From: [Redacted]
Sent: 25 June 2021 14:30
To: 'Amy Myer' <Amy.Myer@arun.gov.uk>; Laura Gibbons <Laura.Gibbons@arun.gov.uk>
Subject: Y/80/21/DOC

Following the engineers comments my engineers has replied and attached revised stuff

In response to the drainage engineer's comments;

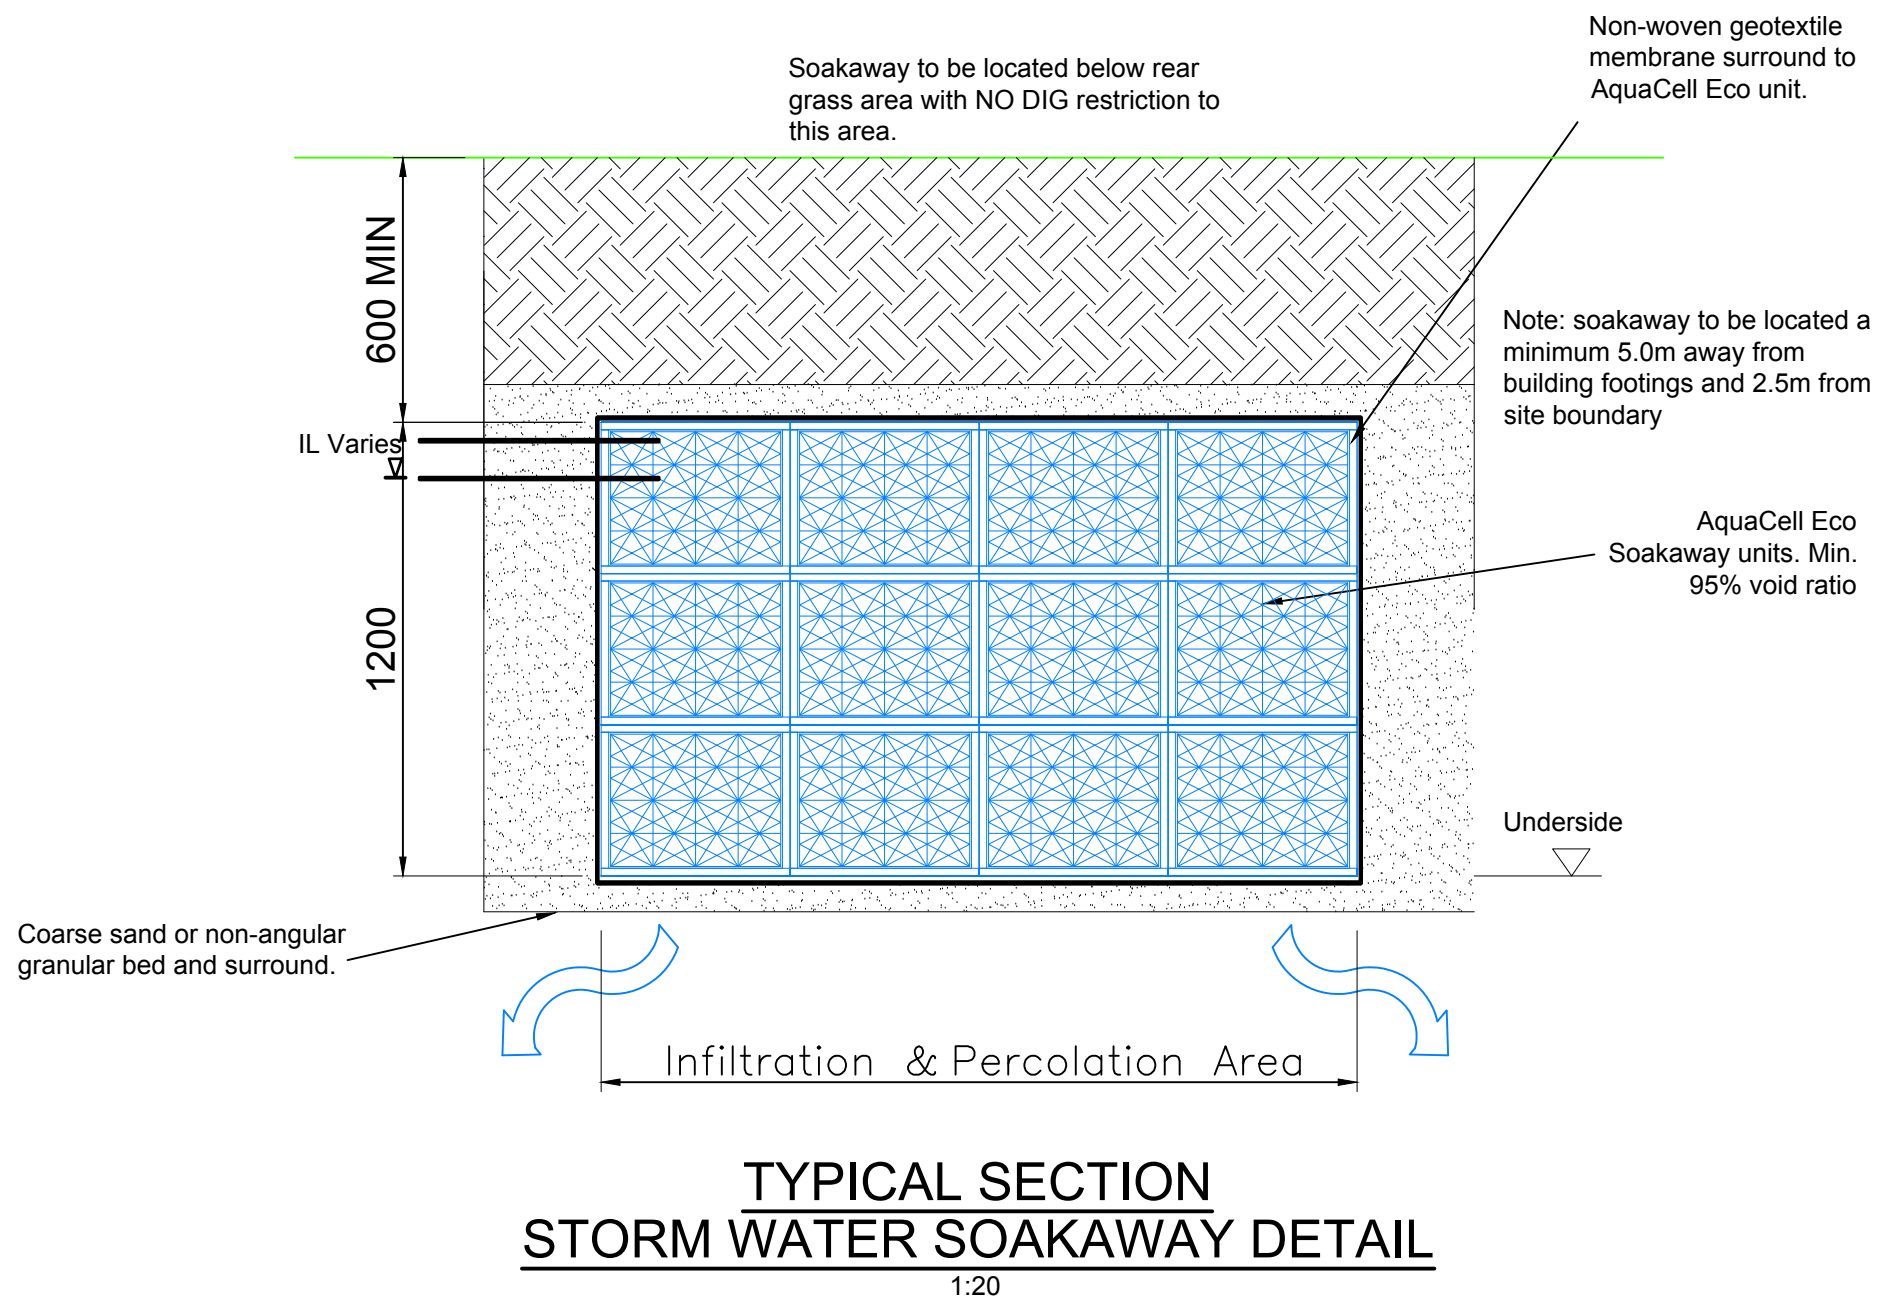
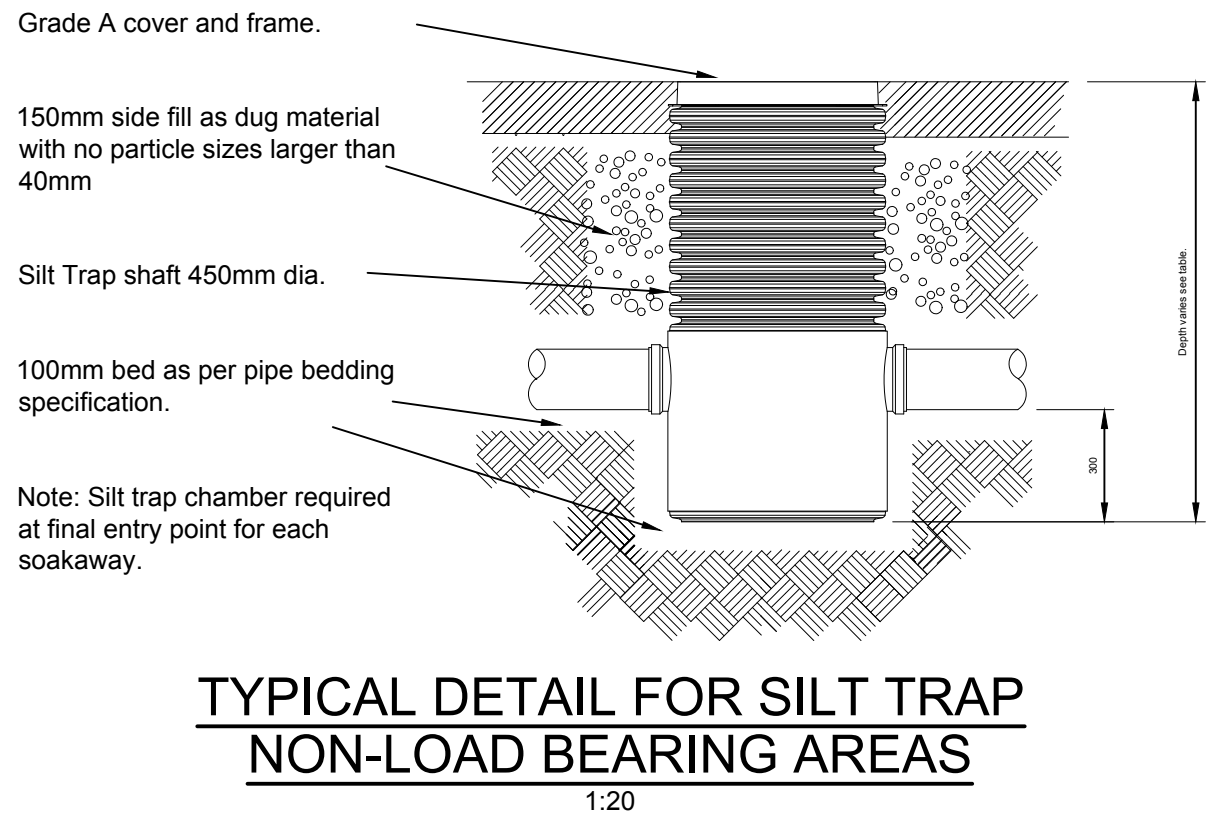
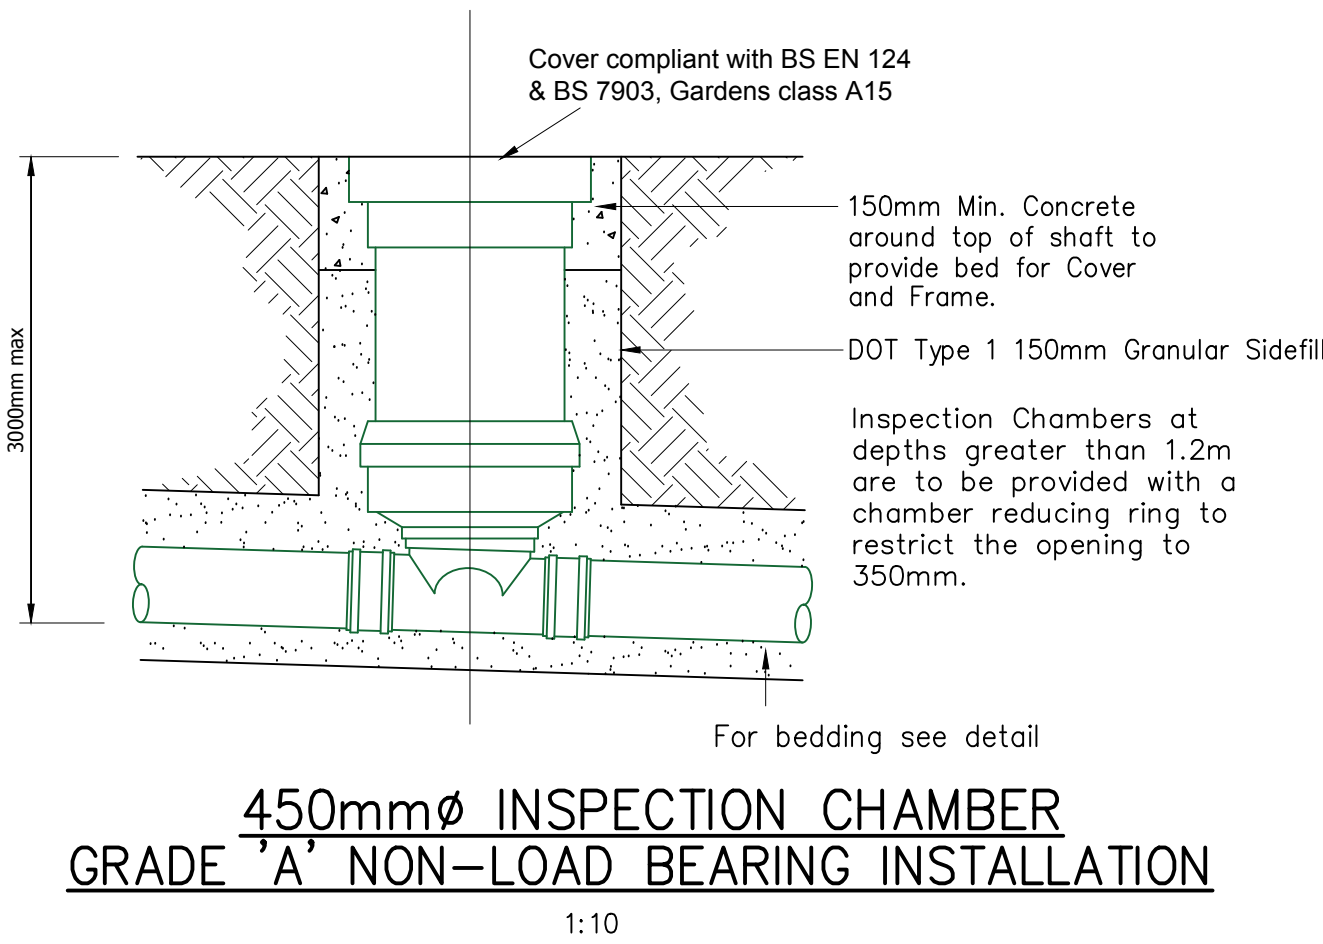
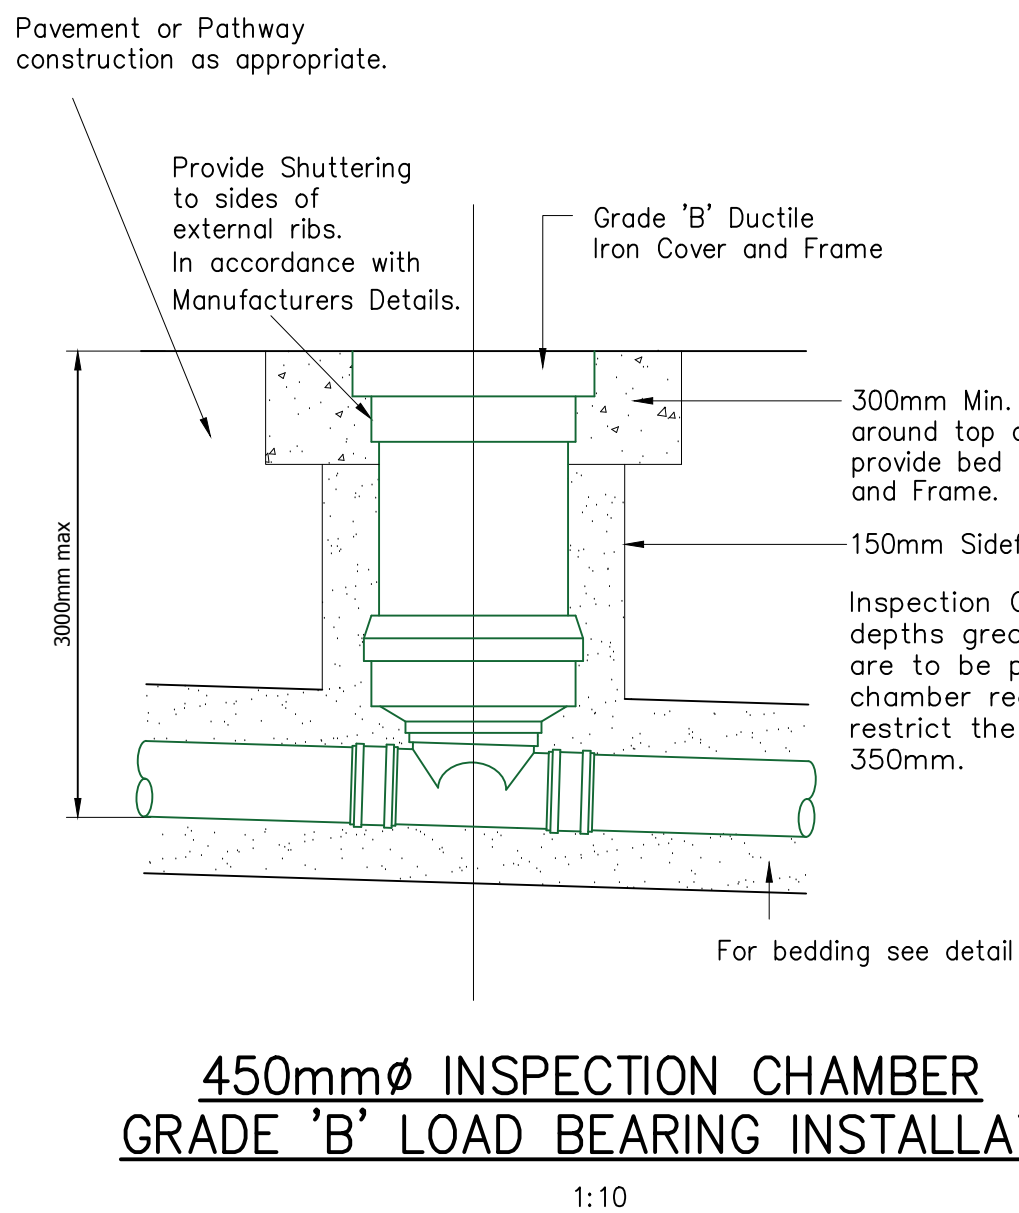
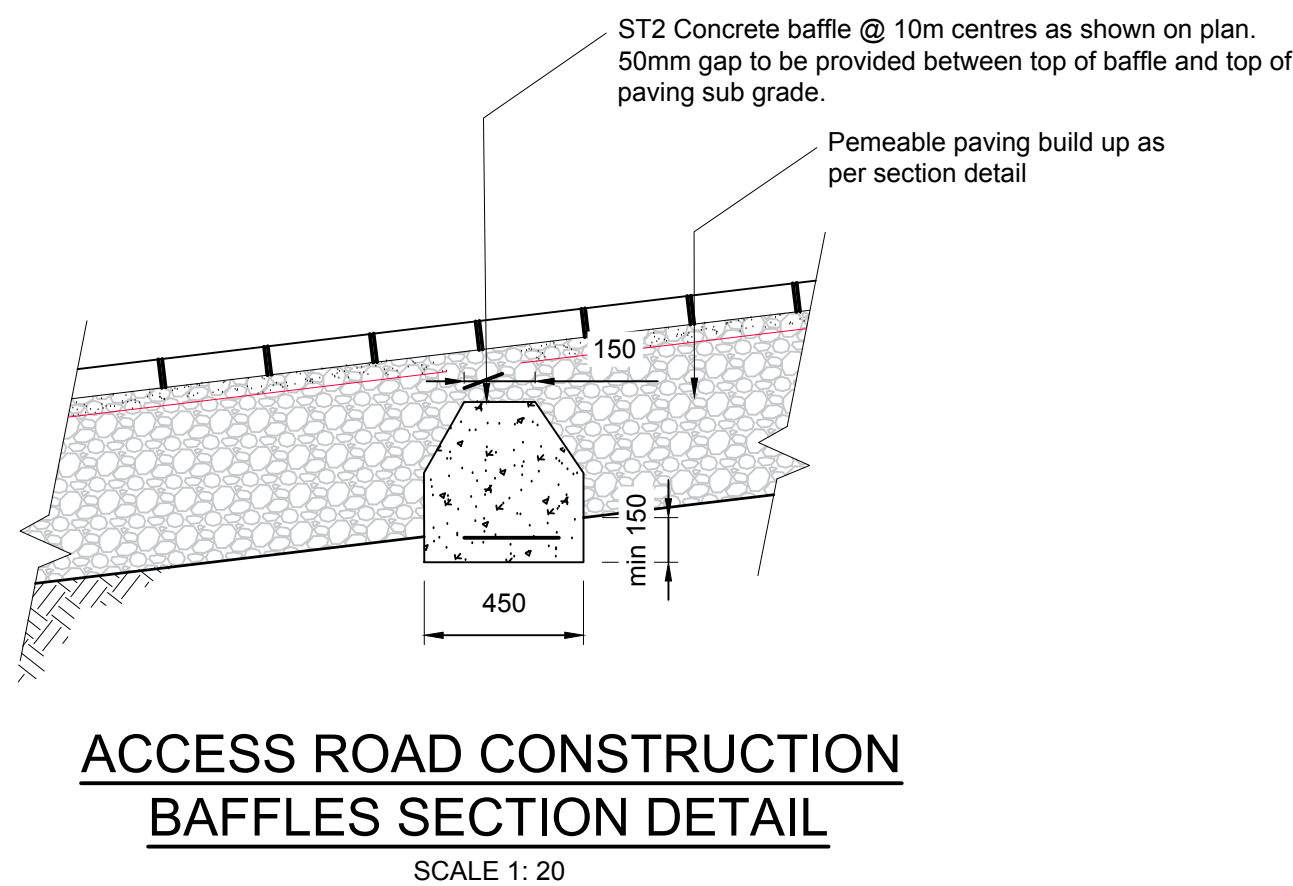
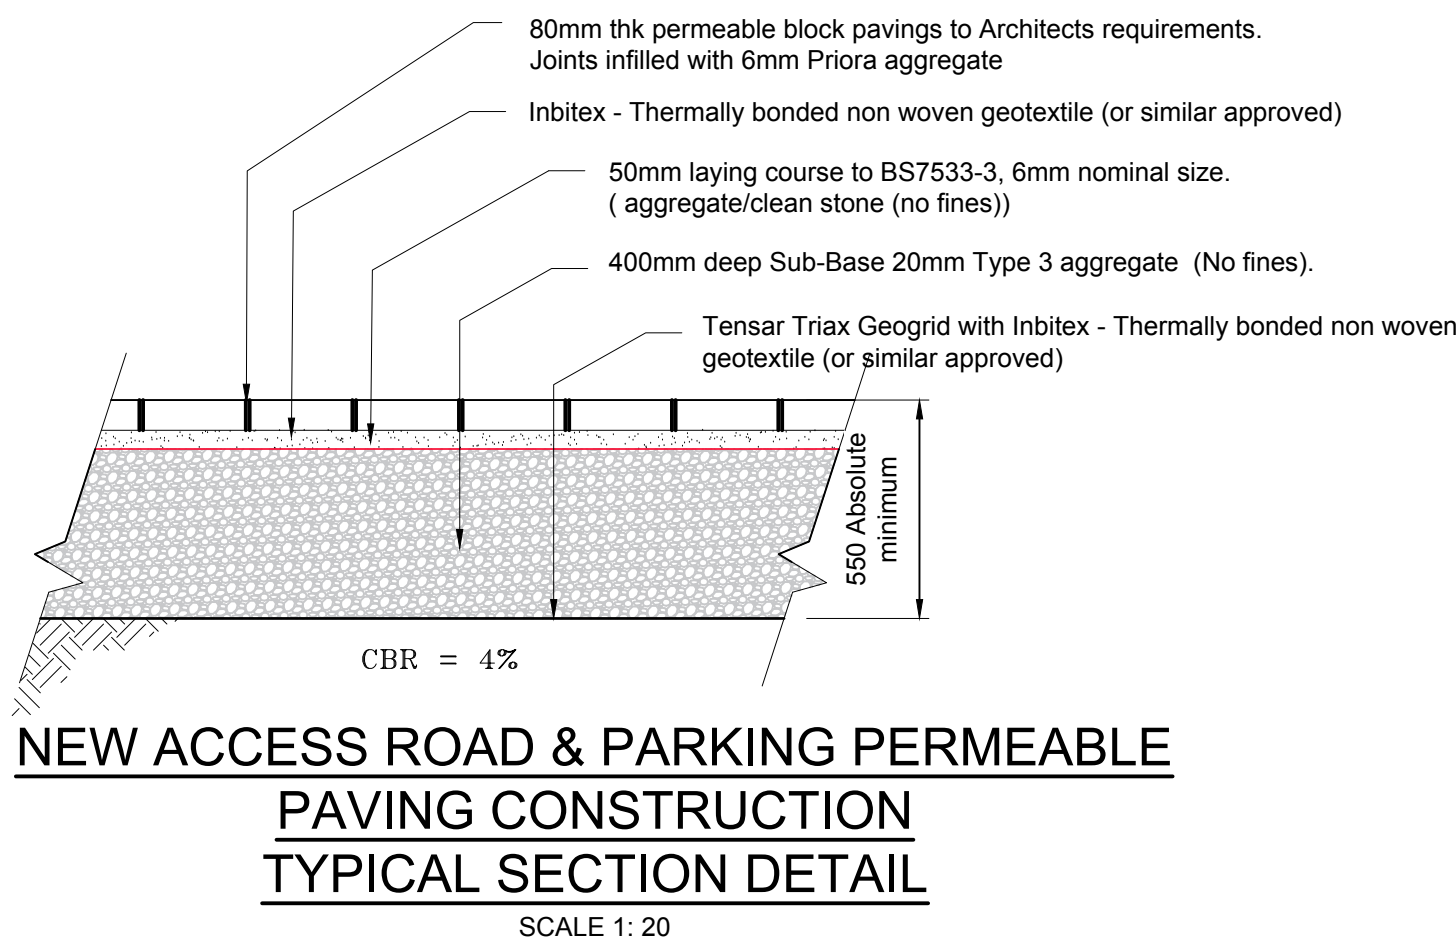
1. I have noted infiltration testing date / locations on the plan and attached to the calculations.
2. I have applied the shallower depth infiltration testing results to the permeable paving design and updated the calculations / drawings. Sub base depth increased to 400mm.
3. Drawings updated (and attached) with permeable paving finish and formation levels.
